Technical Note 001		
Project Name and number:	Church Road, Climping	D2385
Subject:	SW Drainage Planning Conditions	
Client:	Foreman Homes	
Prepared by and Date:	LF	15/08/2025 (Rev 2)

Response to Arun District Councils comments dated 06/08/25 relating to Planning Condition 9 attached to Decision Notice Ref: CM/18/25/DOC.

Drawing Title **Domestic Drainage Layout**
Sheet 8 of 22

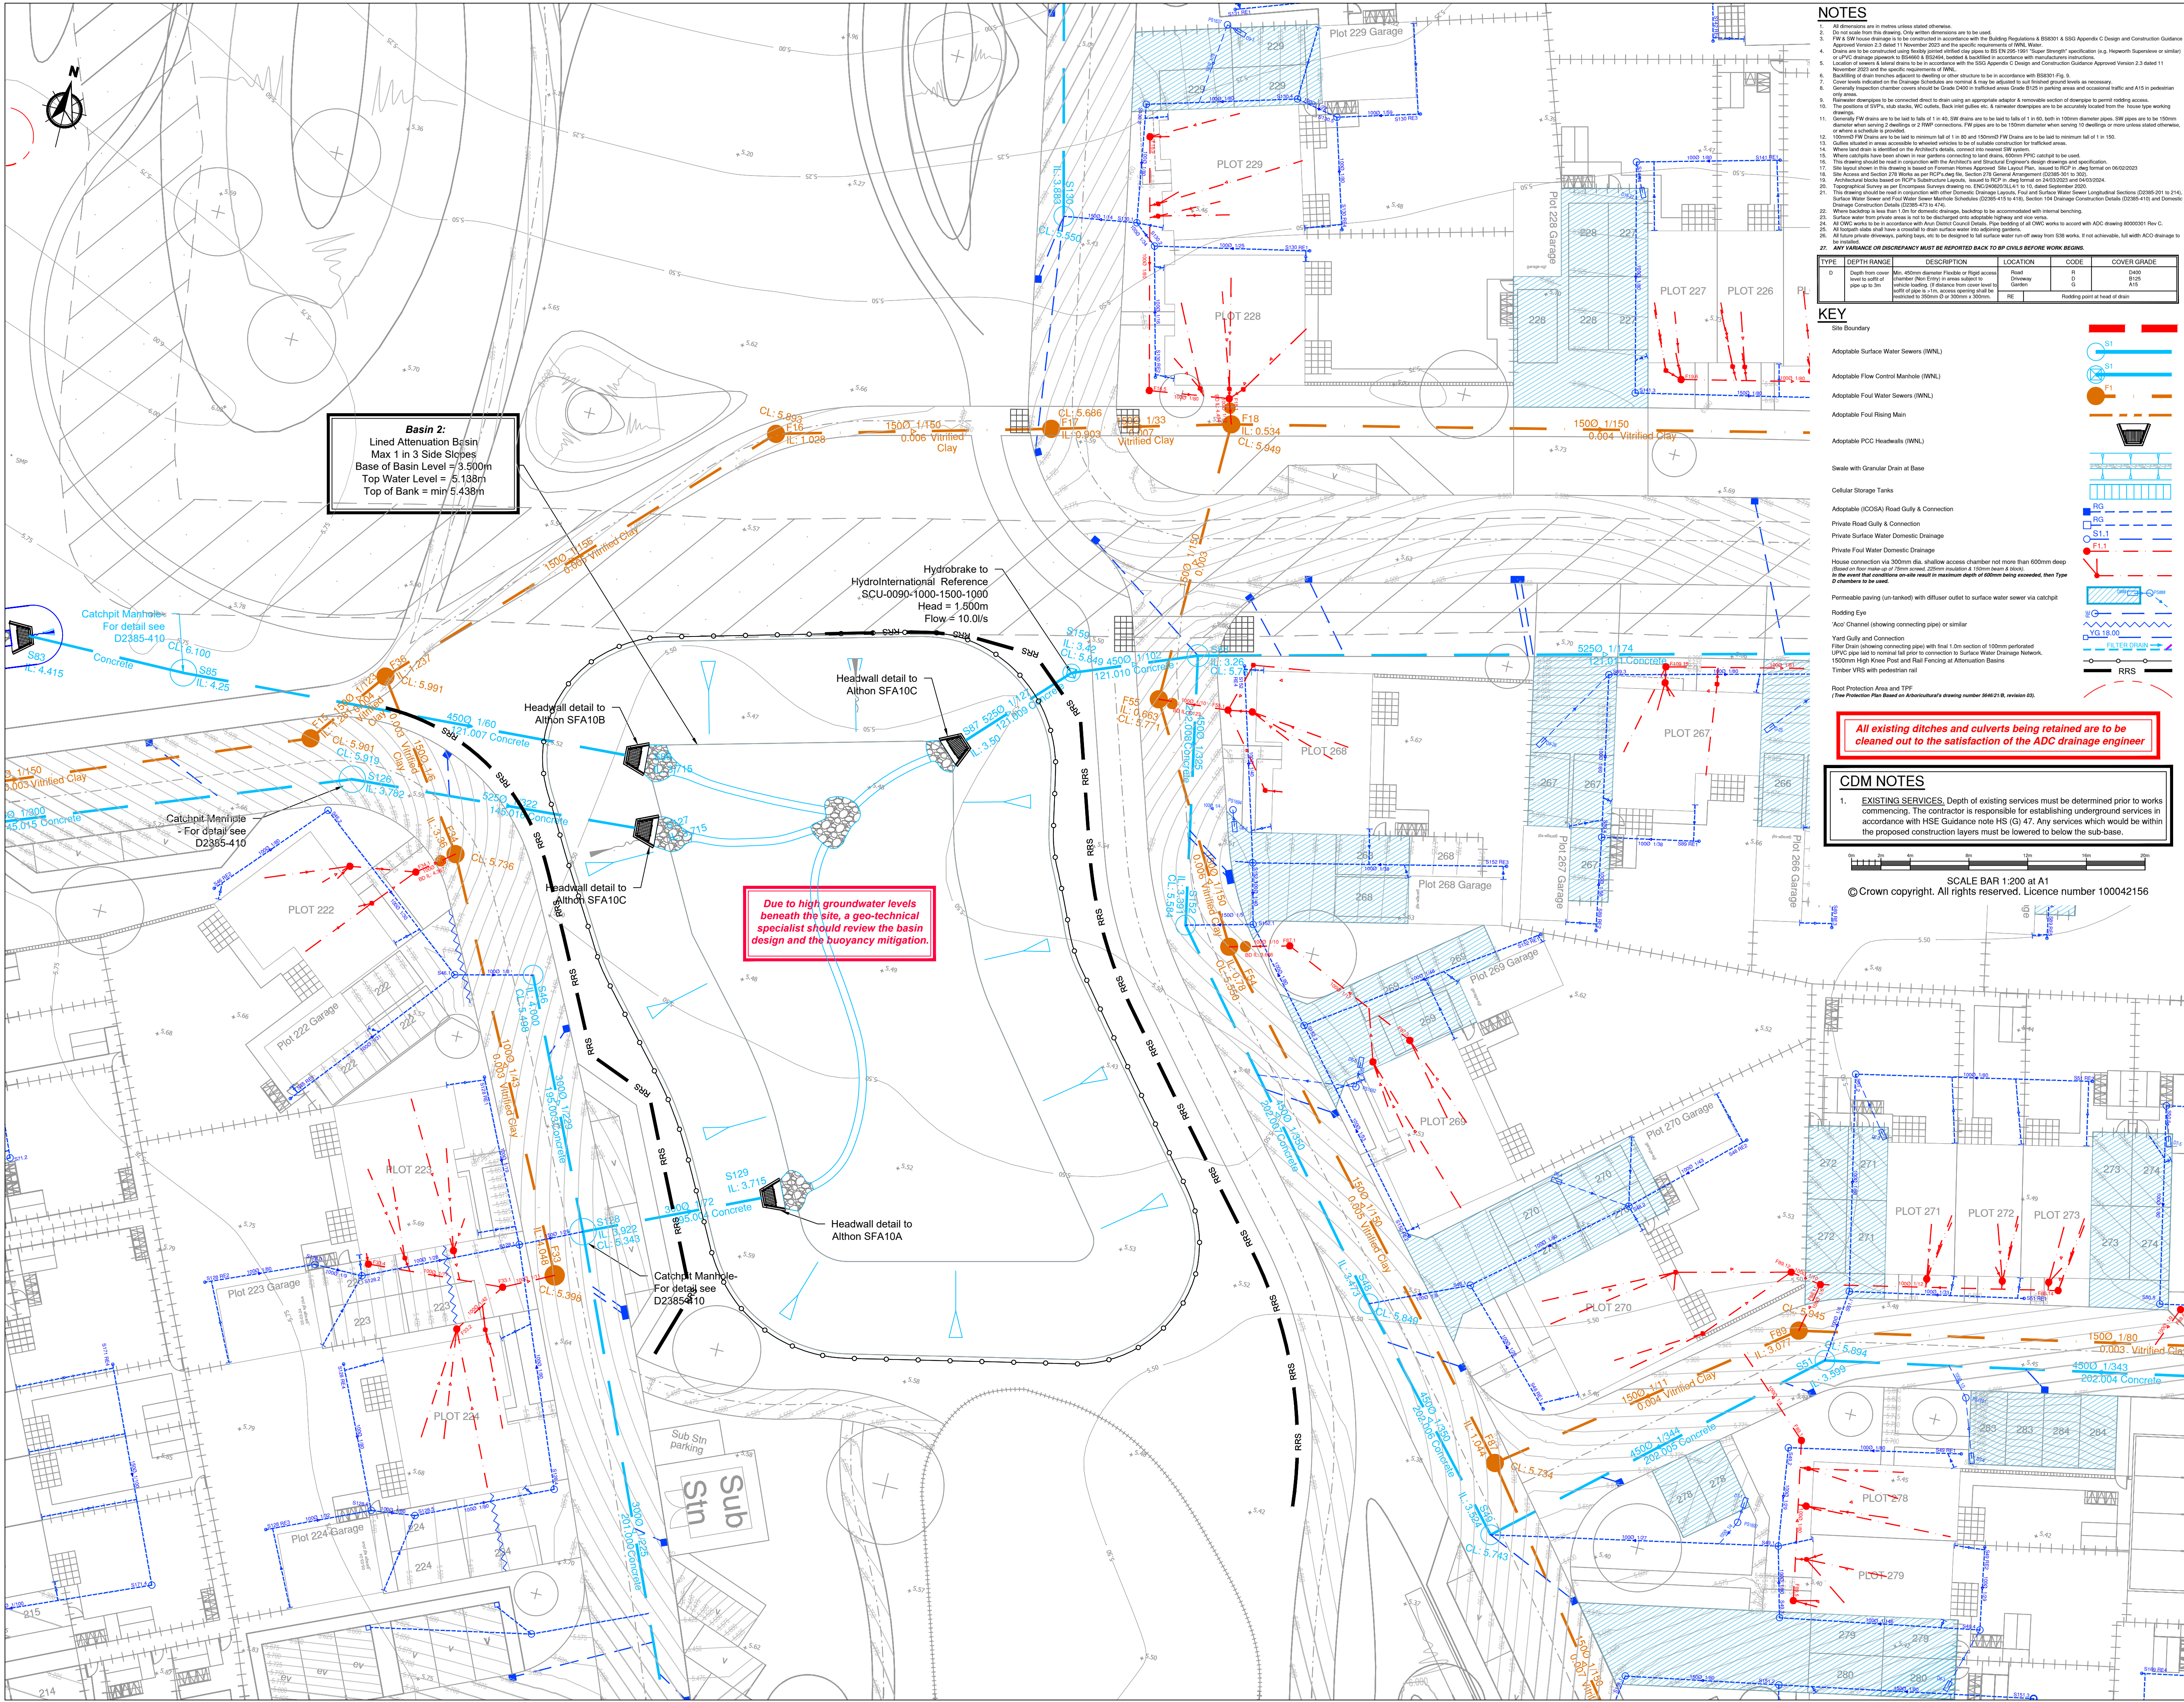
Comment 39

The gullies outside plot 268 should be moved slightly to the lowest local point.

Response

The gullies have been moved to the correct location. Please see drawing referenced 000-BPC-ZZ-D-C/D458, included in this resubmission pack
